Application for outline planning permission for development of 70 bed Care Home and 14 Assisted Living bungalows with associated car parking, landscaping and access -
Departure from the Development Plan.

Land Adjacent to Highfield House Yapton Road Barnham

Thank you for your internet representation made on 12th February 2020 which has been recorded as '**an objection**' with the comments as follows:

SITE PLAN  
1/250

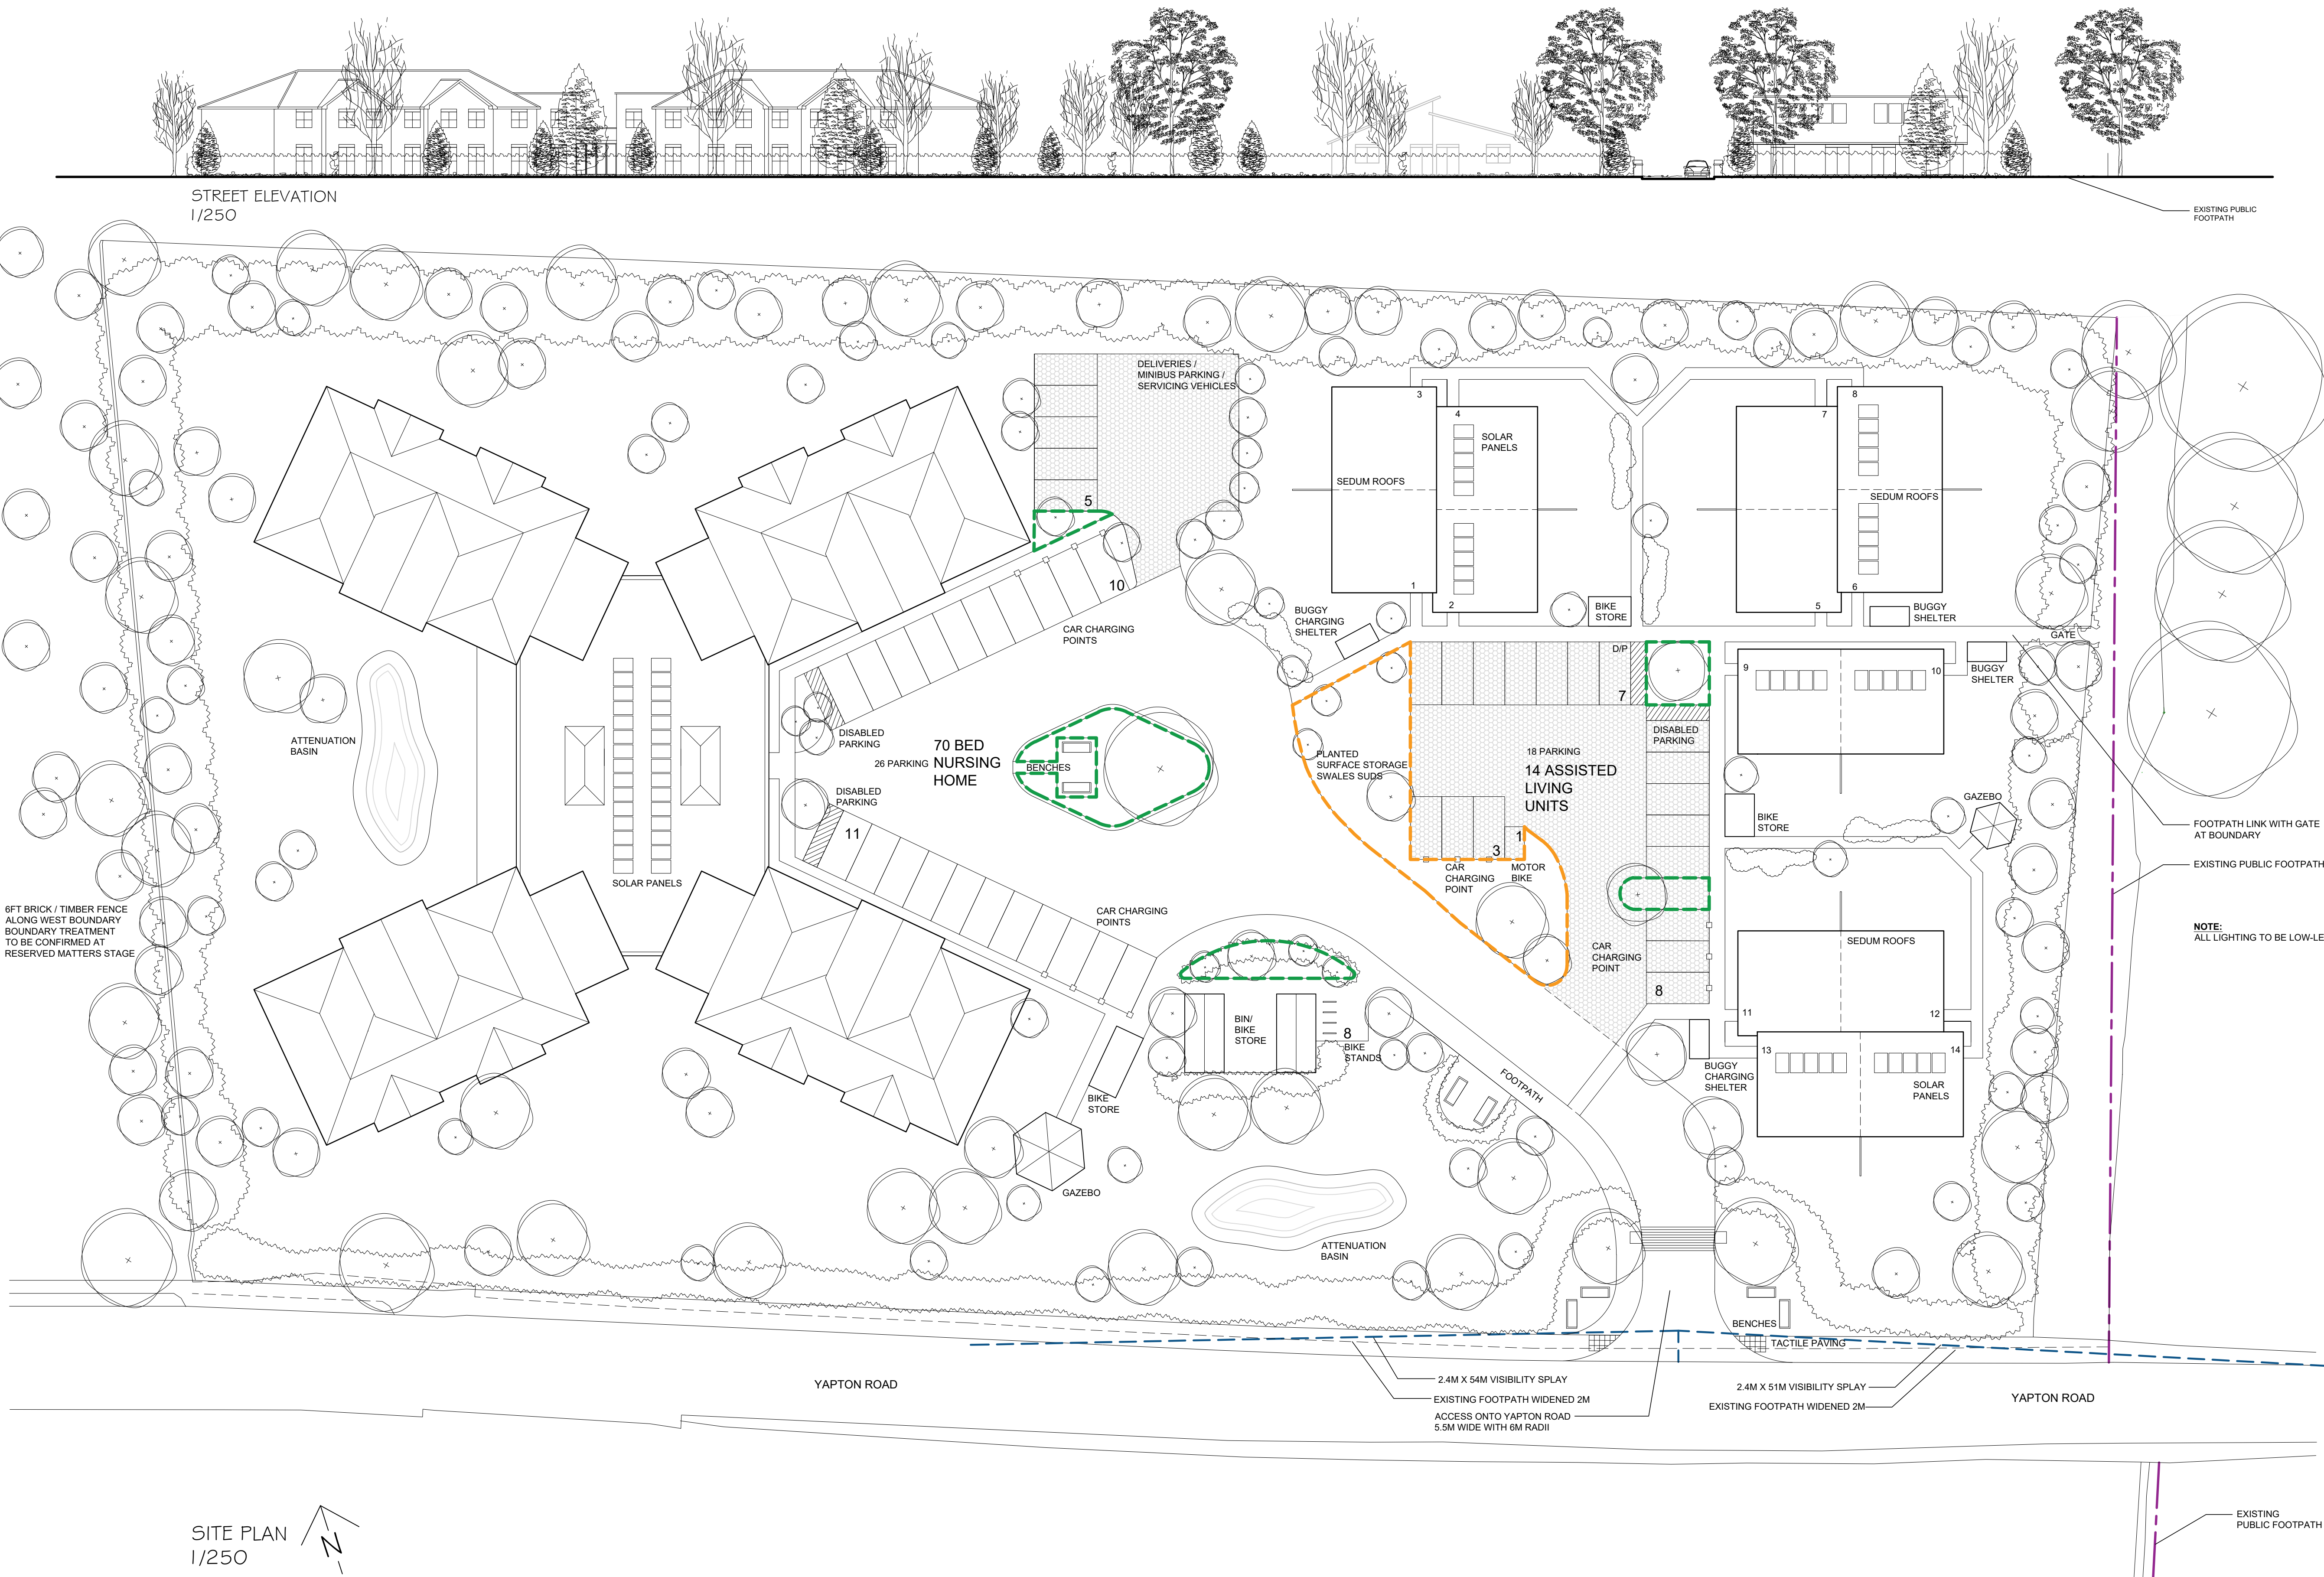
Entrance to the site appears to be directly opposite the development - our house and drive way is opposite and there doesn't seem to be a traffic impact assessment to address and vehicle health & safety issues or recommendations for improvements.
